3 August 2012

**SECTION 75W MODIFICATION REQUEST (MP06_0009 MOD 2) - PROPOSED
GRADE SEPARATION OF THE NORTHERN RAIL SPUR AND ASSOCIATED
INFRASTRUCTURE**

I refer to your letter of 10 July, 2012 seeking Council's comments on the above Modification Request to modify the terms of development consent pursuant to section 75W of the *Environmental Planning and Assessment Act, 1979* (the Act). I also refer to the Environmental Assessment document, dated June, 2012 prepared by Newcastle Coal Infrastructure Group submitted in support of the Modification Request.

Vegetation Mapping

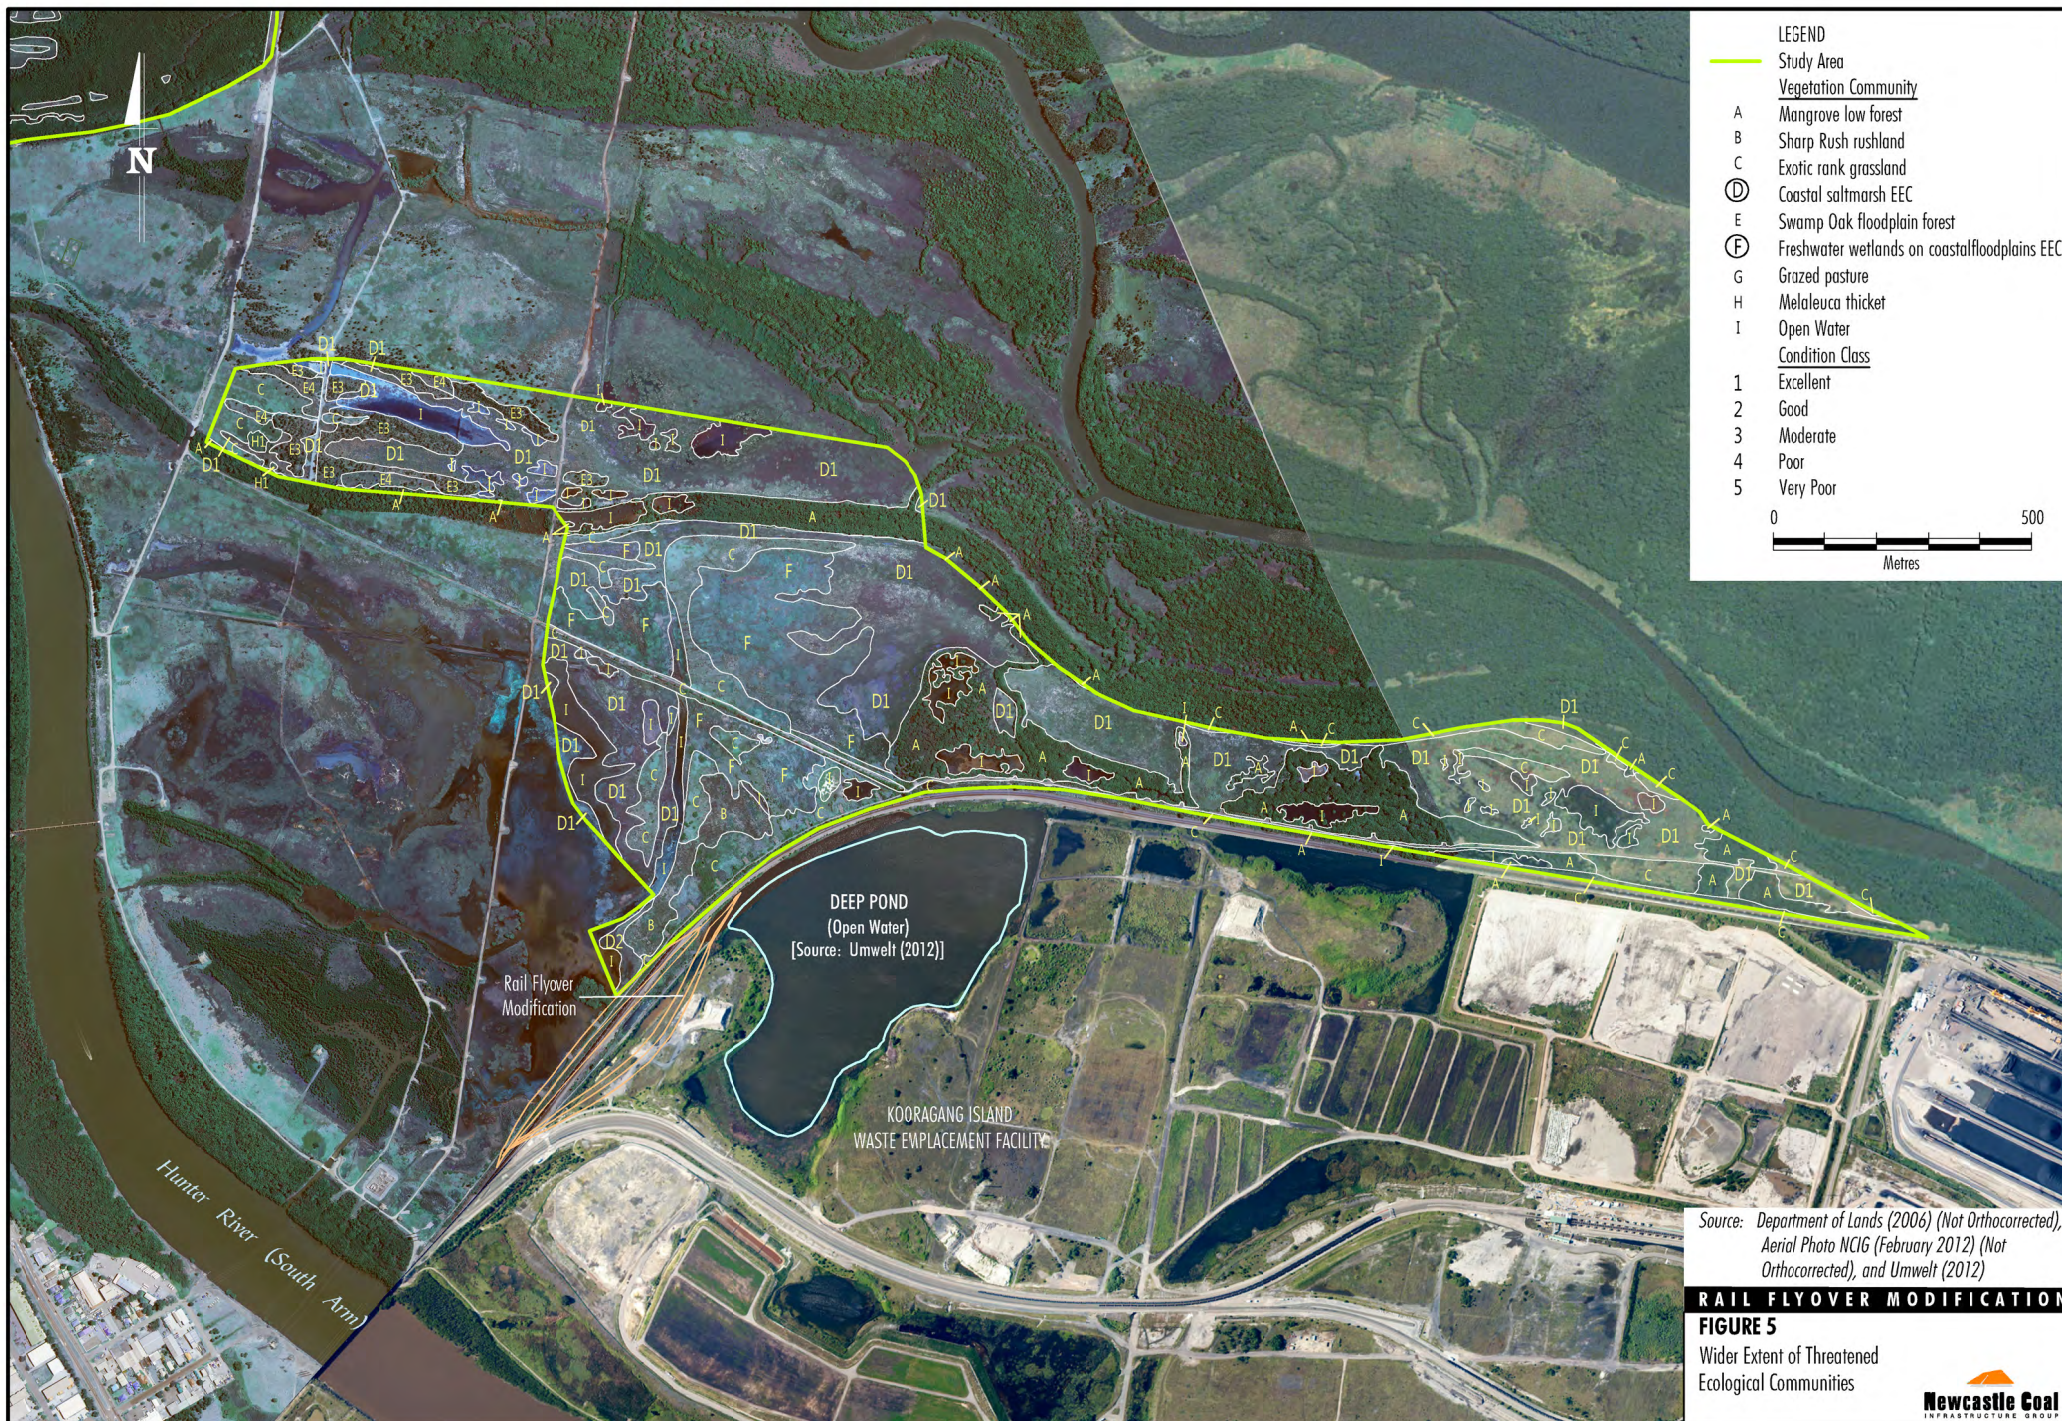
The Environmental Assessment notes the proposed rail infrastructure modification will result in the removal of an additional 2.6 hectares of habitat. Included within the habitat removal are two endangered ecological communities (EEC), freshwater wetlands and salt marsh. While the EA relates that the proposed removal is minor in nature, the resultant reduction continues the incremental loss of habitat, including EEC's, within the Kooragang area. Therefore, it is considered further review of the potential impacts of additional loss of habitat should be undertaken. The EA notes compensatory habitat will be undertaken as a result of the removal of EEC's. The potential compensatory habitat should be defined in the assessment.
